From: [REDACTED]
Sent: 24 July 2019 17:44
To: Laura Gibbons
Cc: Kathryn Griffiths; Caroline Green; Zoe Knott; Ryan Saul; Dorota Kaminska-Majkowska; James Lawson; Lance Else; James Hammond; Darren Mcarthur; Simon Davis
Subject: RE: Y/9818/RES and Y/97/18/DOC

1. The calculations for flotation of the pond are based on the liner being at 0.6m depth below ground water level. We agreed to assume ground water level at the surface in this area, i.e. 6.8mAOD. The invert level of the pond is 6.2mAOD, and there is 0.41m depth of top soil above the liner. The liner is therefore actually 1.01m below ground water level. The calculations need to be adjusted to account for this and more stabilising forces will be required. NAUE have revised their calculations to assume ground water at 6.8mAOD and have advised that the depth of soil now required is 1.38m so we have updated our detail to reflect this.
okay Noted

Scale AS SHOWN @ A1	Date JUNE 19	Designed JA
Drawn JA	Checked LH	Approved LH
Job No 18-070	Drawing No 18-070/114	Rev C

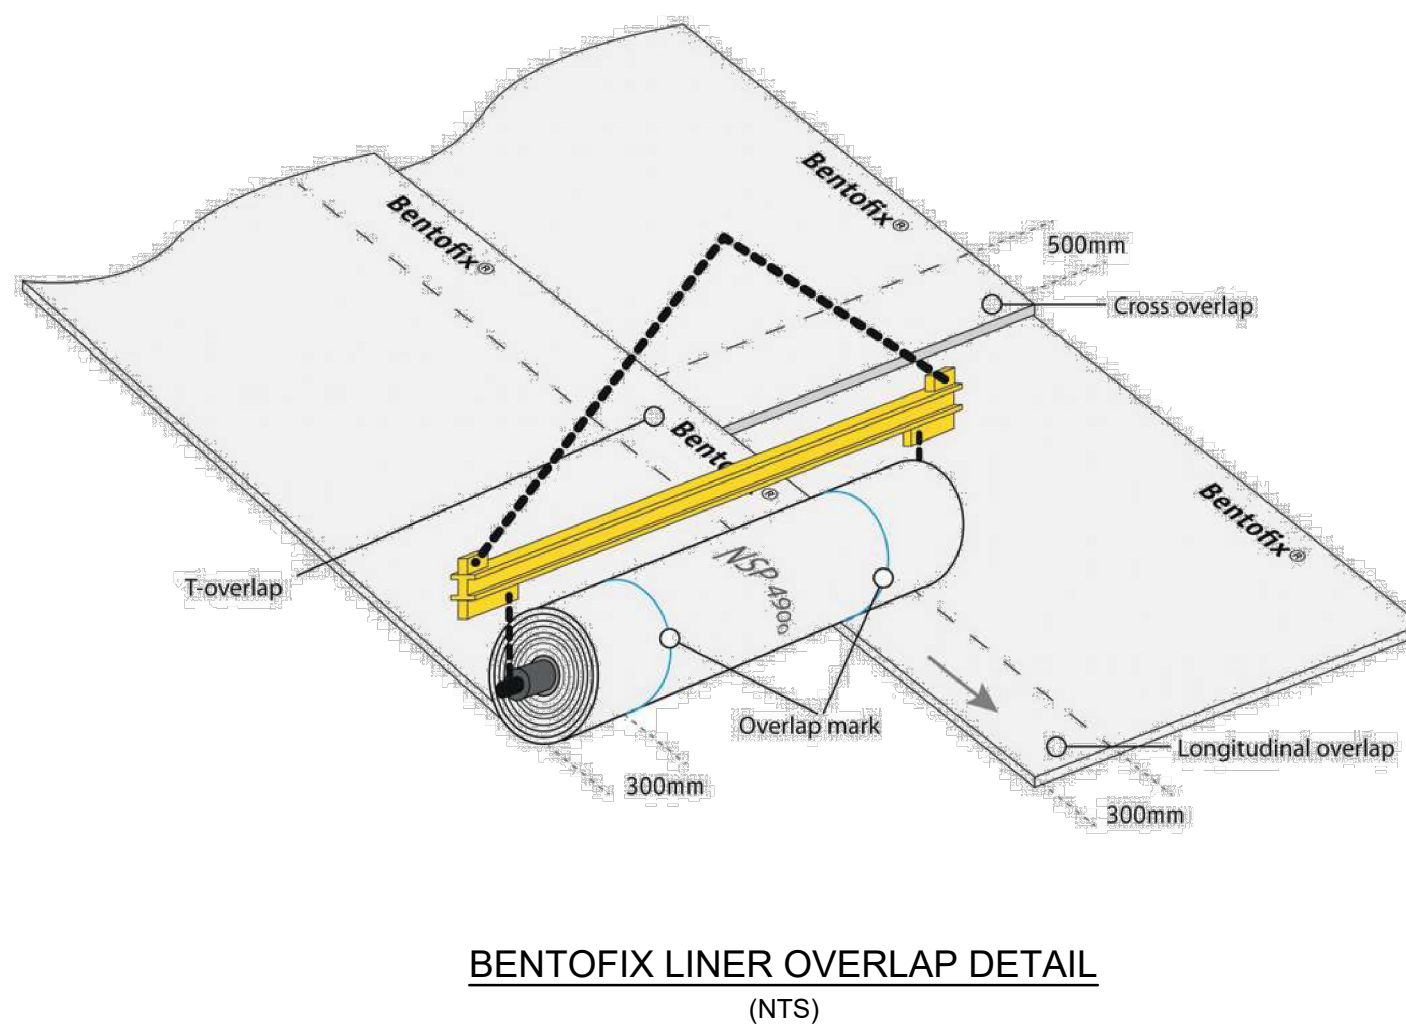
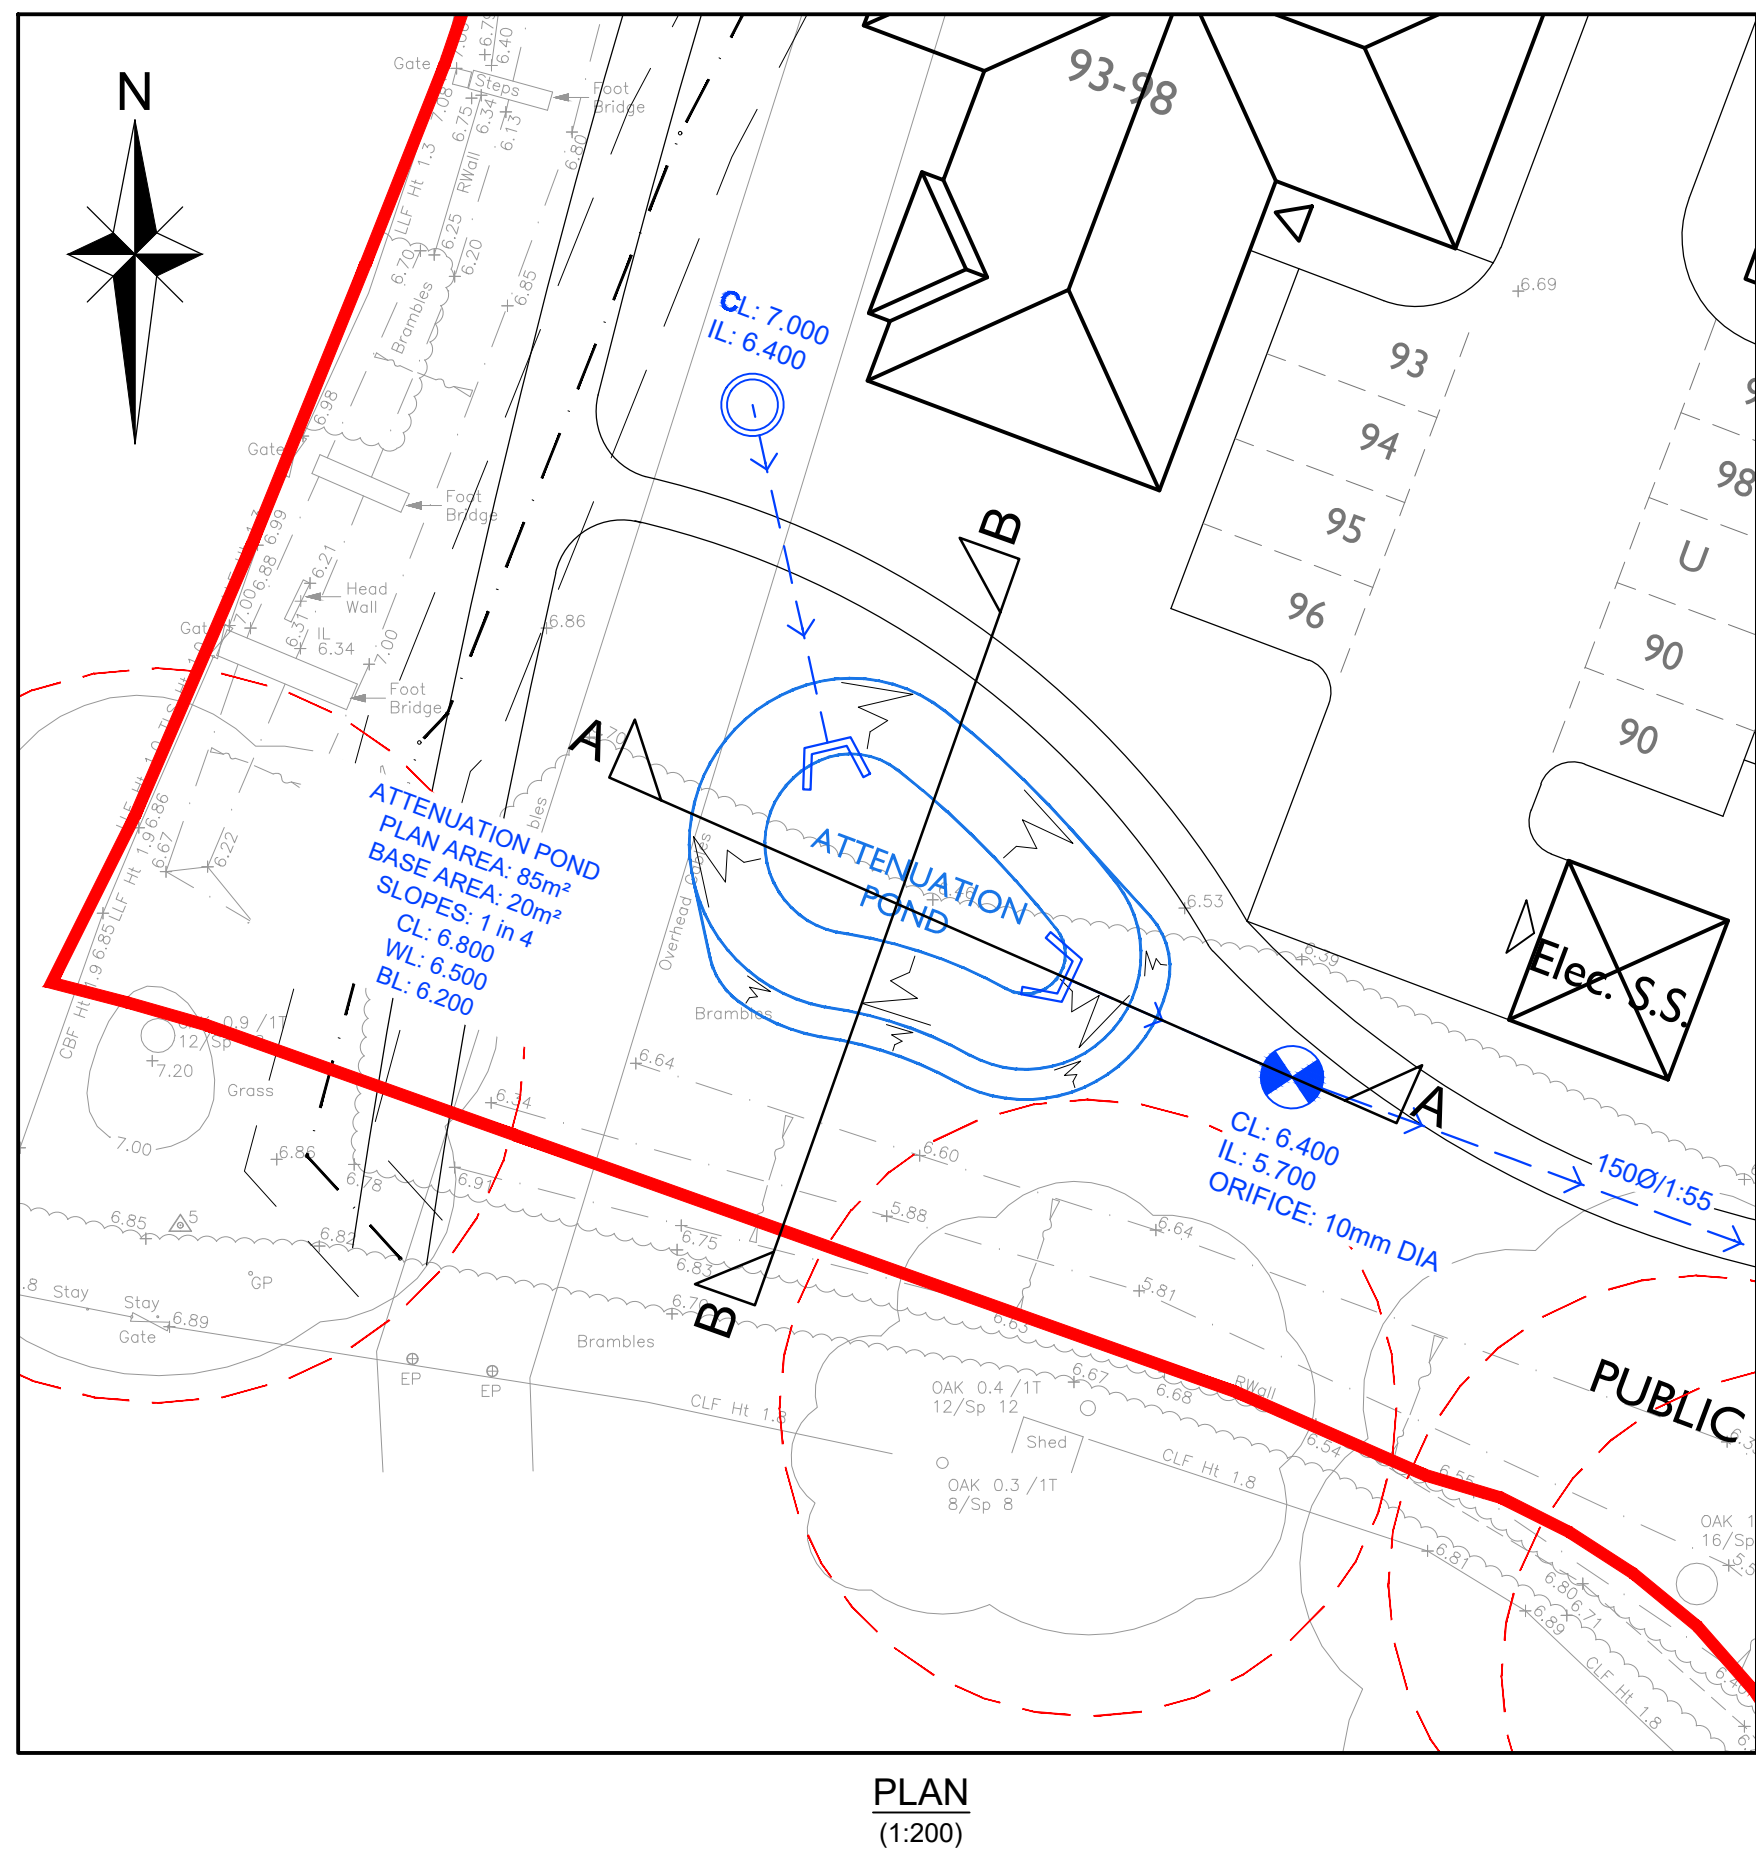
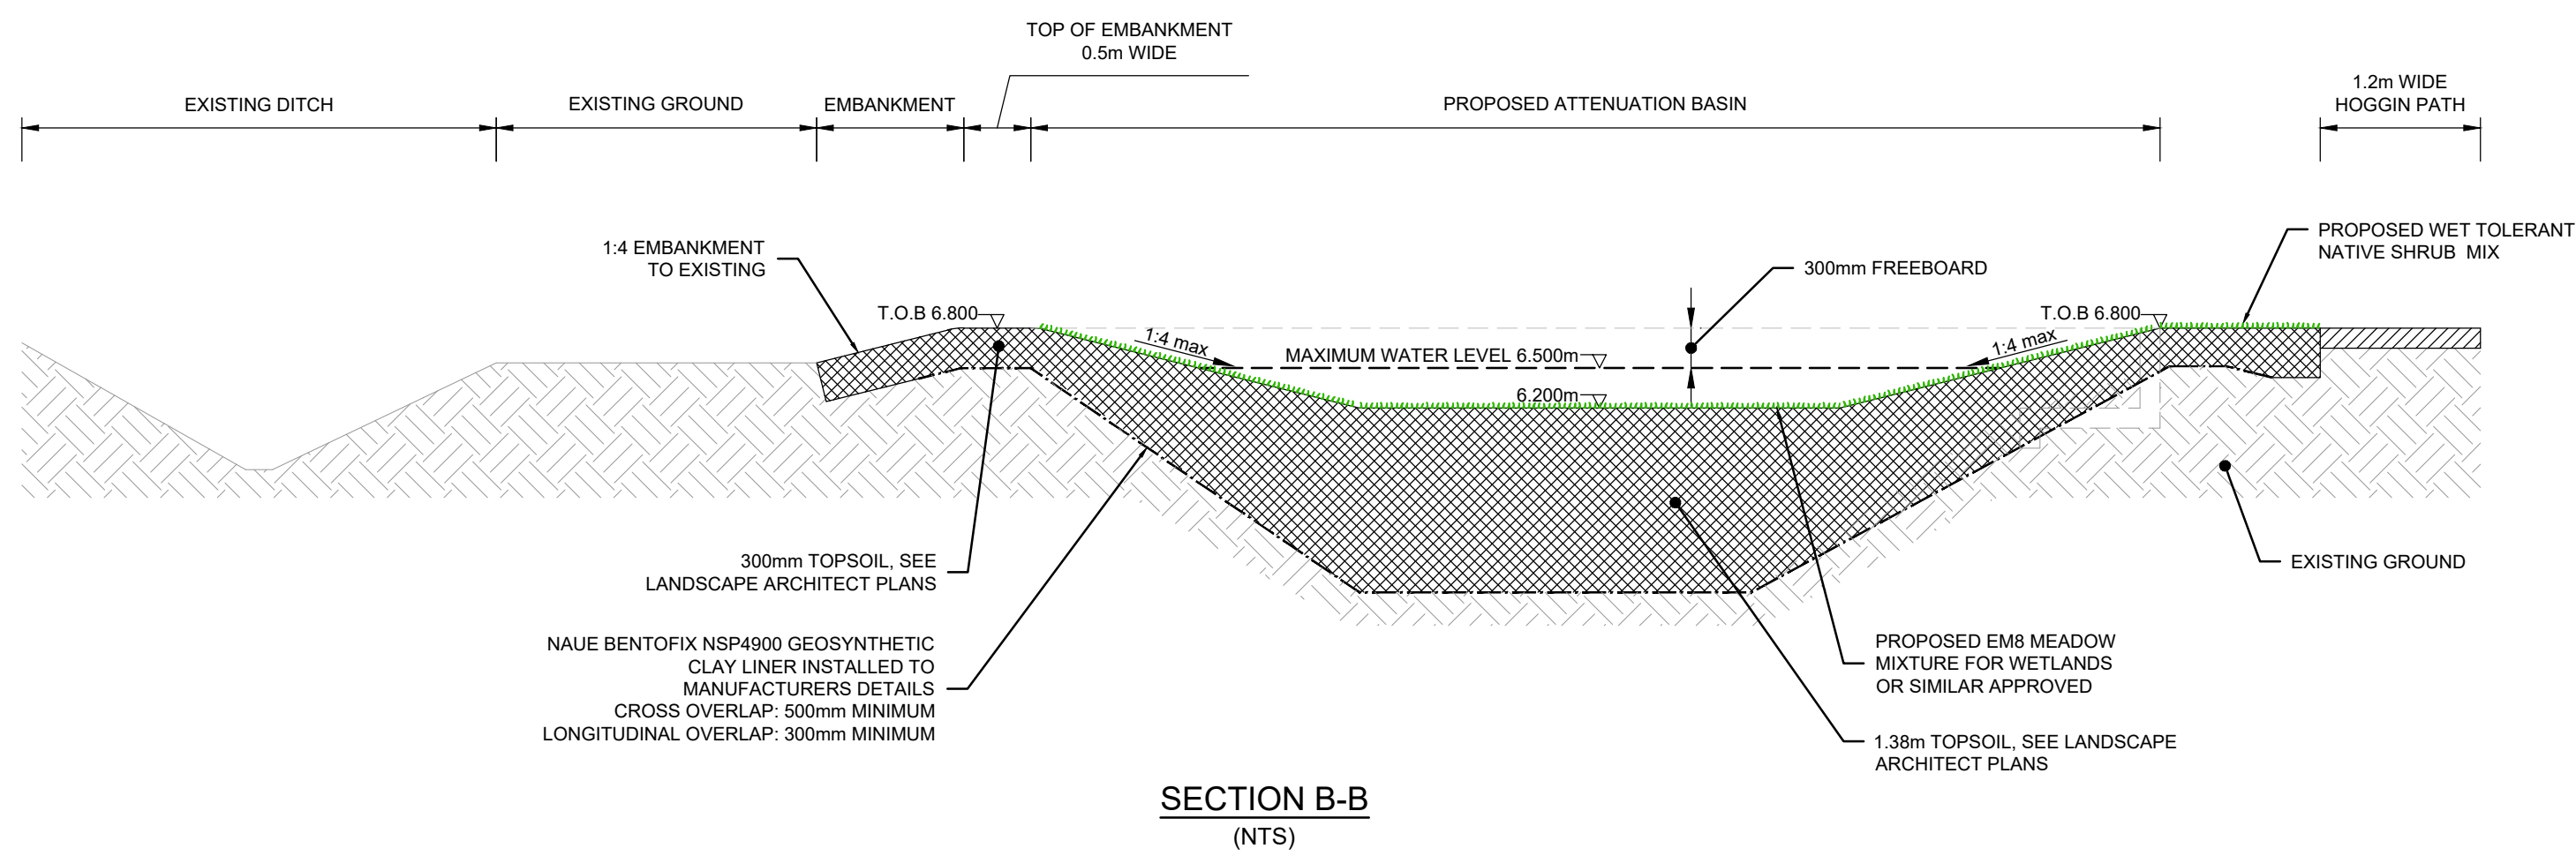
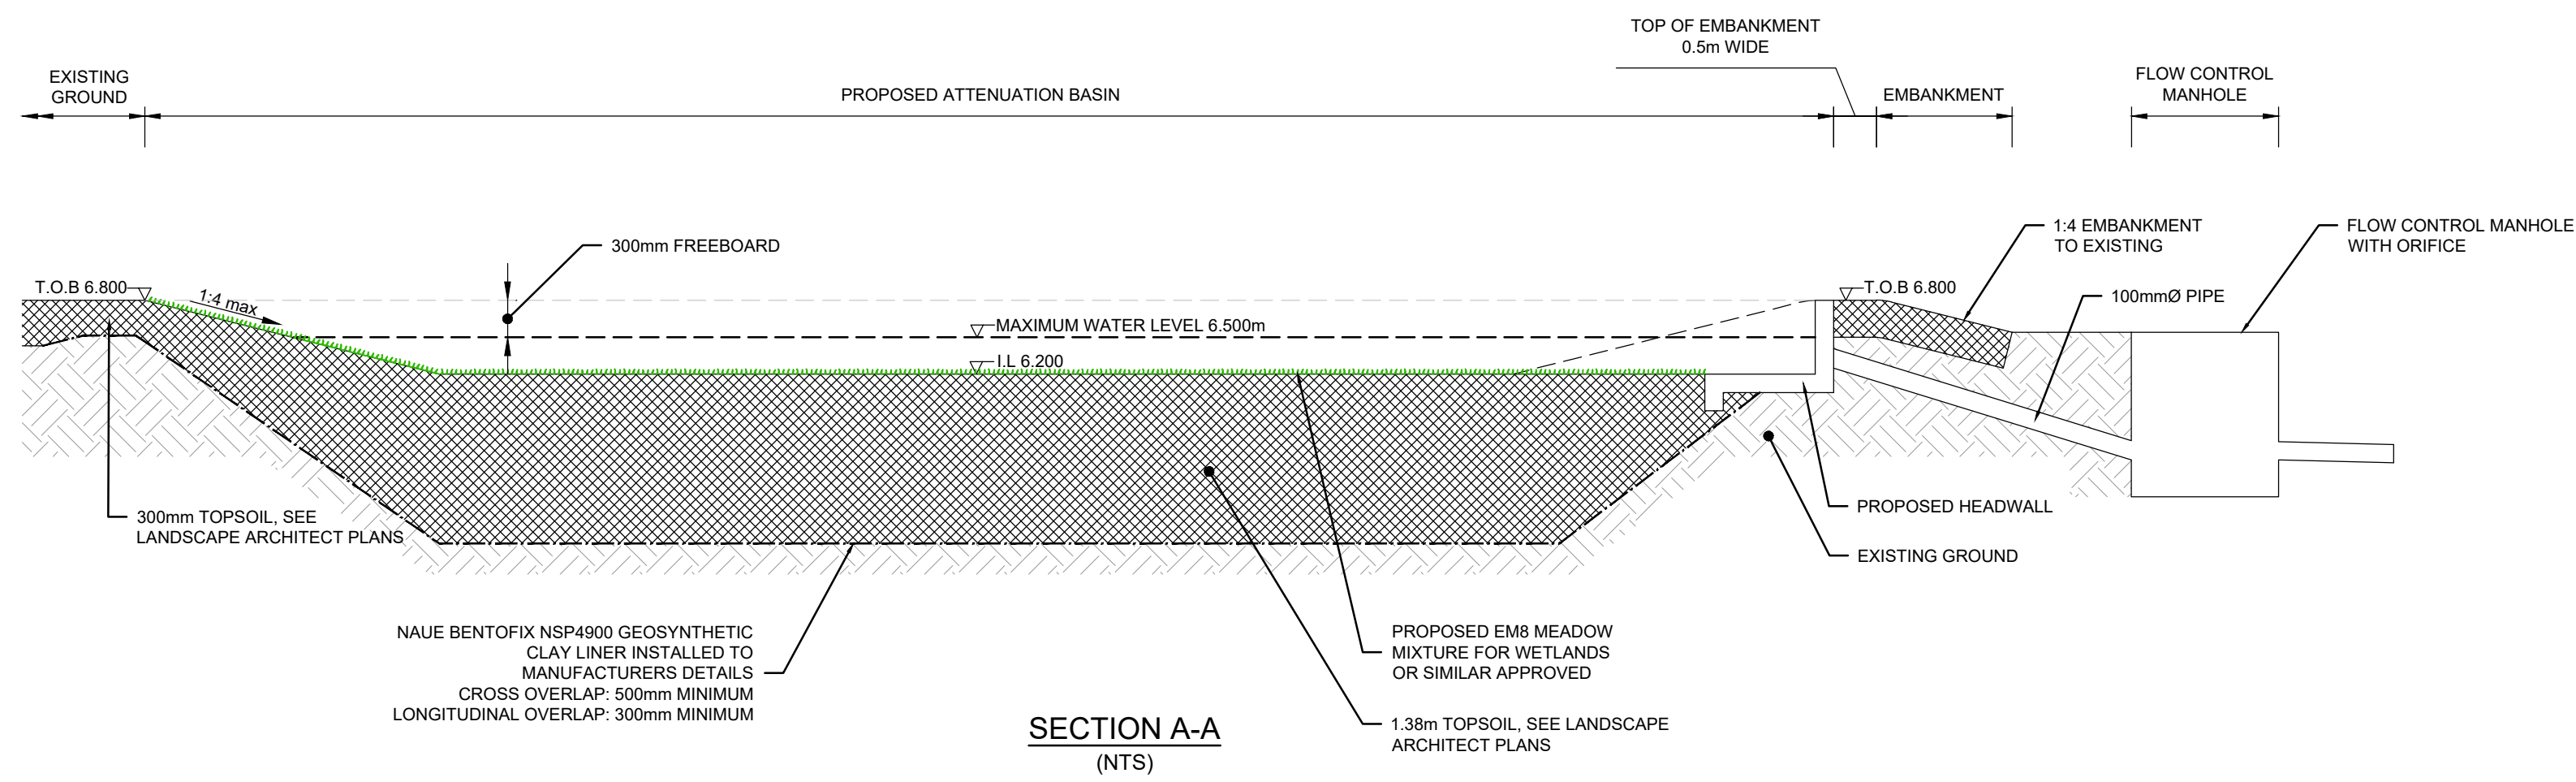
5. Please update the construction detail drawings to show permeable geotextile wrap fully around the sub-base. Detail has been updated. *Please update so geotextile is under tarmac, not over it. Detail amended and attached.*

8. In some locations there are significant drops between orifice invert level and the invert level of the main surface water pipe. Please provide a detail that accurately represents this. Detail has been added to drawing 18-070/111.
